From: Laura Hobbs
Sent: 12 January 2021 10:10
To: Victor Grayson
Cc: Amy Reddick
Subject: RE: Chidswell - Yorkshire Wildlife Trust

Thank you for consulting us on the Ecological Design Strategy (EDS). I have the following comments to make:

Figure 2 Proposed Site Plan

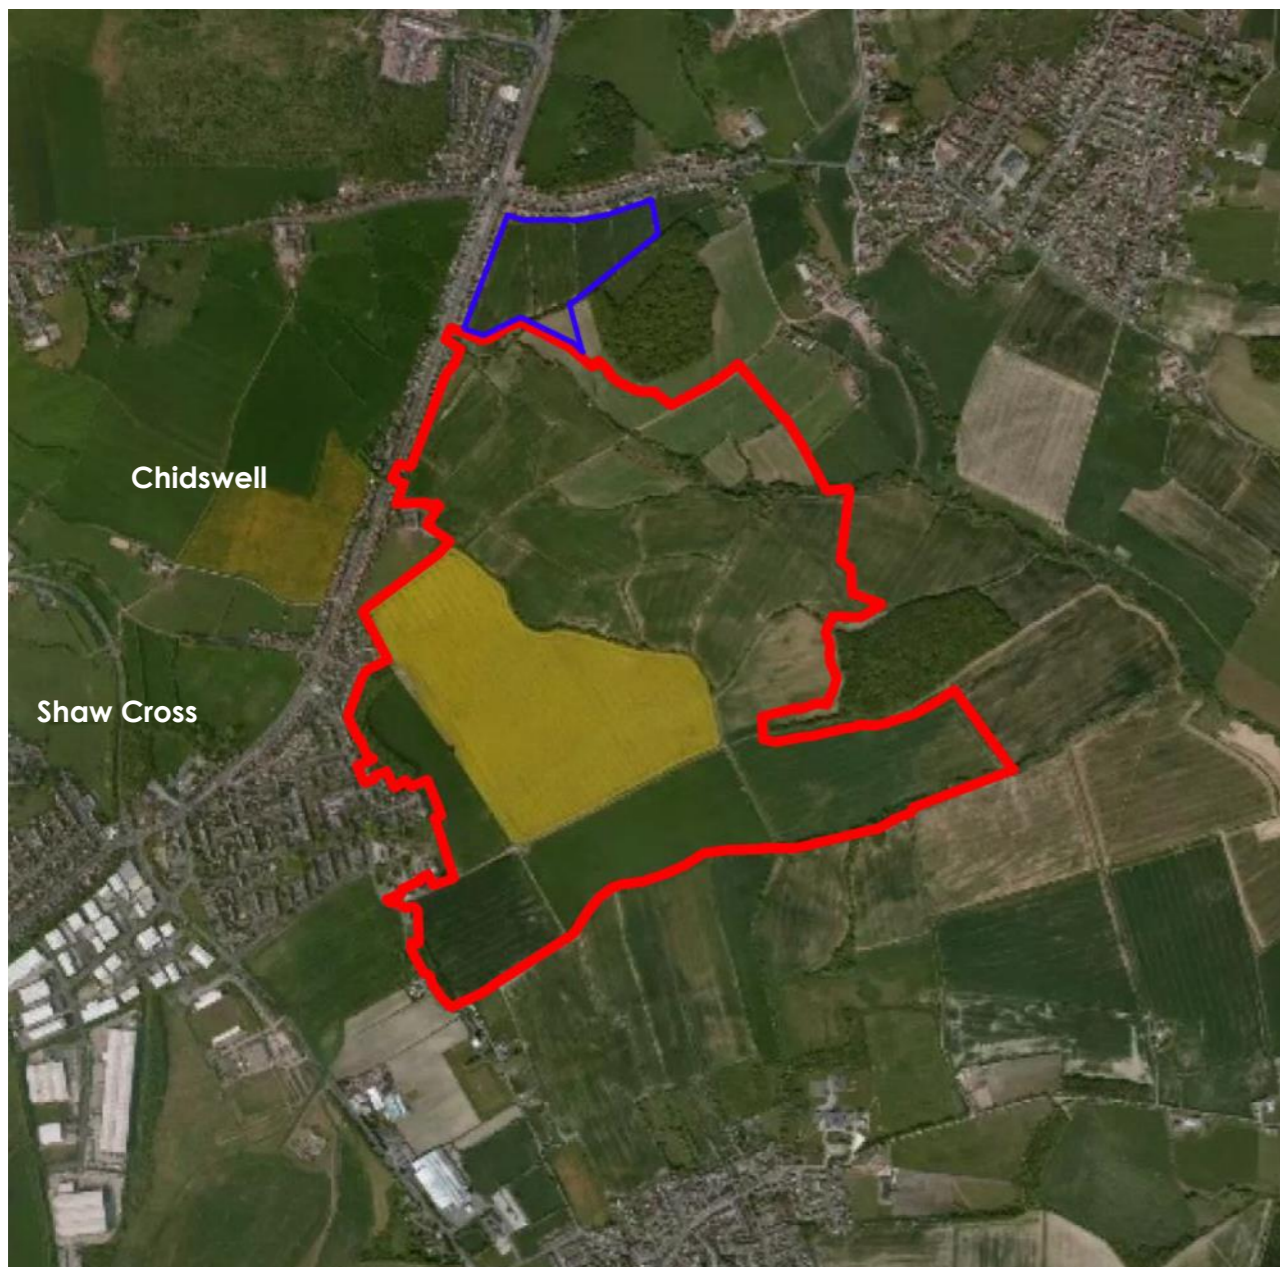
The EDS does not take into account the precautions to be put in place to protect adjacent AW and LWS from impacts of the development (i.e. increase in footfall, domestic animals, fly tipping/littering etc.). We previously requested, at the minimum, a planted buffer rather than fence line only to protect these sites. The ecologist responded by stating: *'We will address this point by identifying appropriate mixed-species scrub/ tree planting as buffers, within the EDS and subsequently the BMP.'* This is not shown within the current EDS.

With regards to species mitigation, we also disagree that breeding birds have been appropriately considered. Ground nesting birds were identified on site and require bespoke mitigation, for instance skylark plots, which does not appear to be incorporated into the design at this time. As no wintering bird surveys have been undertaken at this time, a precautionary approach to the impacts of the loss of wintering and breeding bird habitat should be taken with regards to development design.
